KIRKLEES METROPOLITAN COUNCIL INVESTMENT & REGENERATION SERVICE

DELEGATED DECISION TO DETERMINE APPLICATIONS FOR CONSENT, AGREEMENT OR APPROVAL REQUIRED BY CONDITION

Reference No:	2026/44/90240/W
Site Address:	Huddersfield Bus Station, Upperhead Row, Huddersfield, HD1 2JN
Description:	Discharge of details reserved by conditions 12 (phase 1 surface water management), 17 (external plant or machinery), 31 (phase 1 bus disruption plan) and 32 (phase 1 foundation proximity to railway) on previous permission 2025/91604 for Variation condition 2 (plans) on previous permission 2024/92302 for refurbishment comprising (phase 1): facade improvements including Henry Street entrance; replacement shop fronts; alterations to external bus apron; extension and alterations to existing barrier within the bus alighting lane adjacent to Henry Street; (phase 2): new entrance canopy; public realm improvements; cycle hub; facade improvements including replacement shop fronts
Recommending Officer:	Liz Chippendale

DECISION – Discharge of Condition – Approve

DRAWING TITLE
MECHANICAL SERVICES
 HENRY STREET
 HEATING AND COOLING LAYOUT

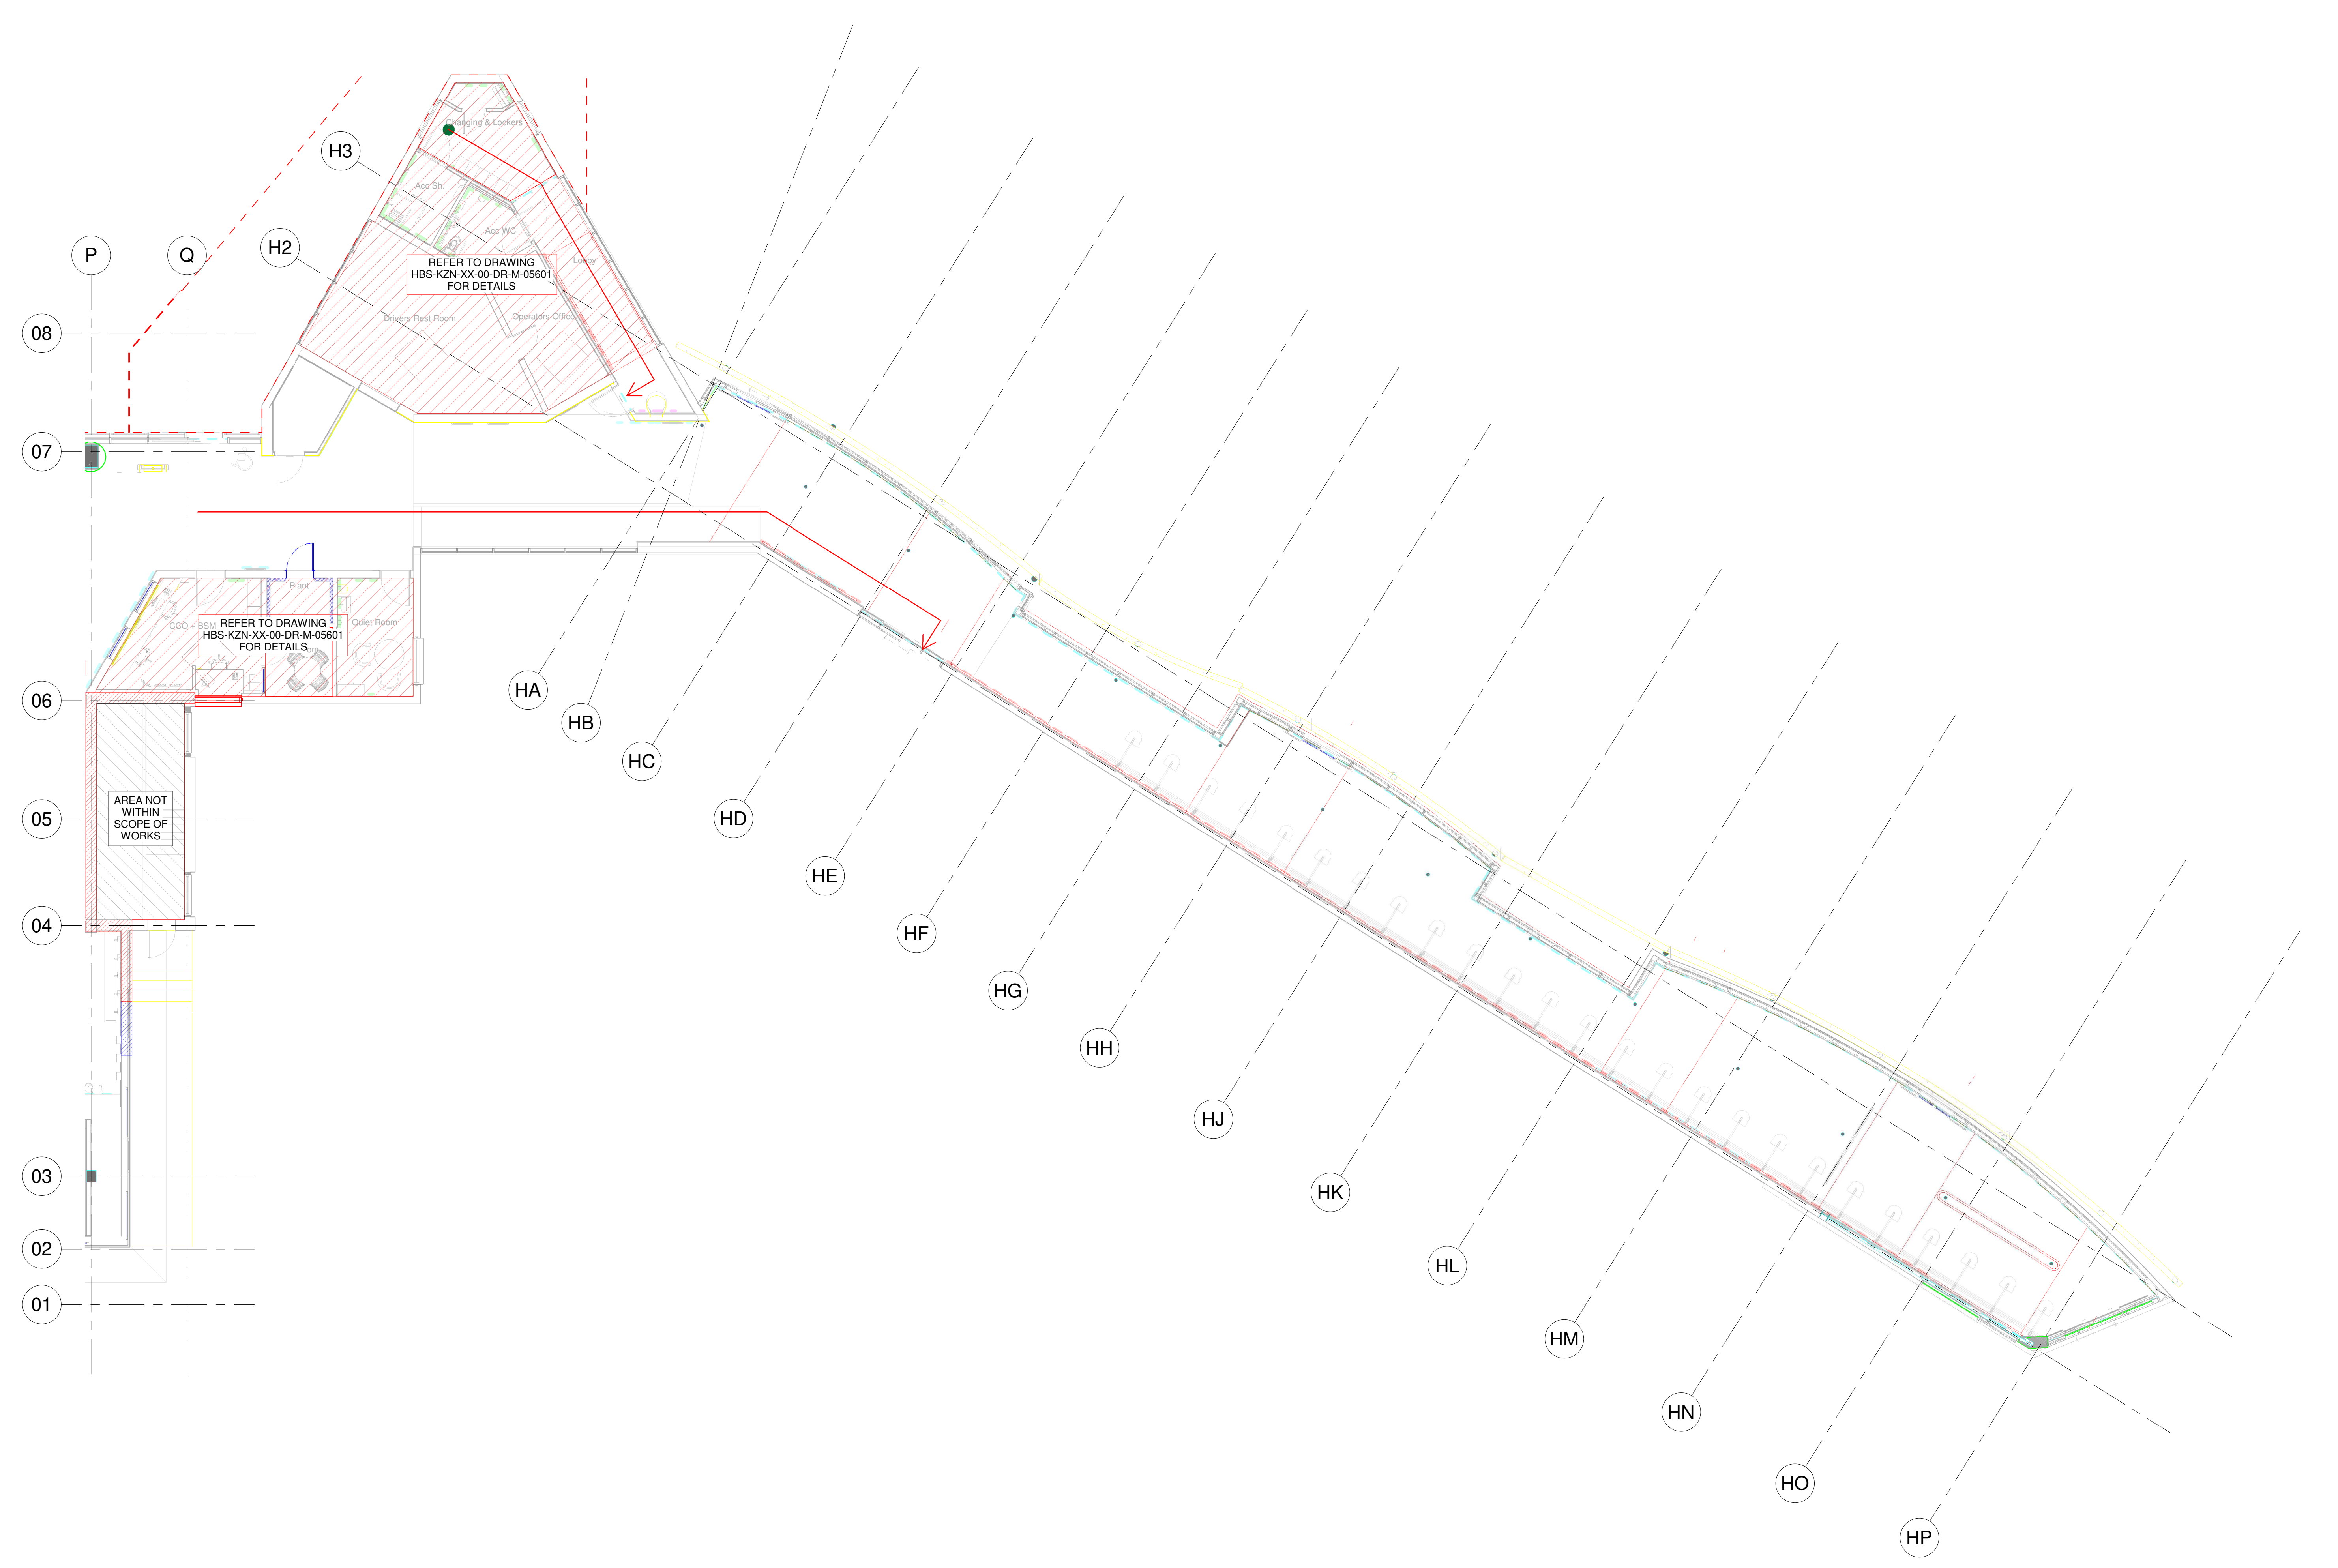
The proposal includes the fixing of two external condenser units located to the rear of the bus station, on the south elevation of the protruding triangular section which is adjacent to the bus bays. Due to the secluded position of the units, to the rear of the bus station, there is no considered impact on visual amenity or on the character and setting of adjacent listed buildings. The units are small in scale and would be visible by users of bus bays A-E but would be seen in the context of the bus station and therefore not out of keeping.

The nearest sensitive noise receptors to the site are residential dwellings are located to the east at The Old Warehouse, Henry Street which has a separation distance of 38.5m from the proposed plant and is separated by the entrance to the operational bus station which will generate an existing level of noise. Residential units are also located at Dundas Works, Upperhead Row to the south which is separated by the bus station building. To the north and west are substantial retaining walls, holding the ring road.

The application is supported by full specifications of the two proposed units which include base noise levels. Given the separation distances and location of sensitive noise receptors and the existing level of noise generated from the operating bus station, the base levels submitted are considered acceptable. As such, the proposed external plant/machinery is unlikely to have any undue impact on nearby sensitive receptors.

The details provided are sufficient for the requirements of condition 17. Therefore, condition 17 is recommended for discharge.
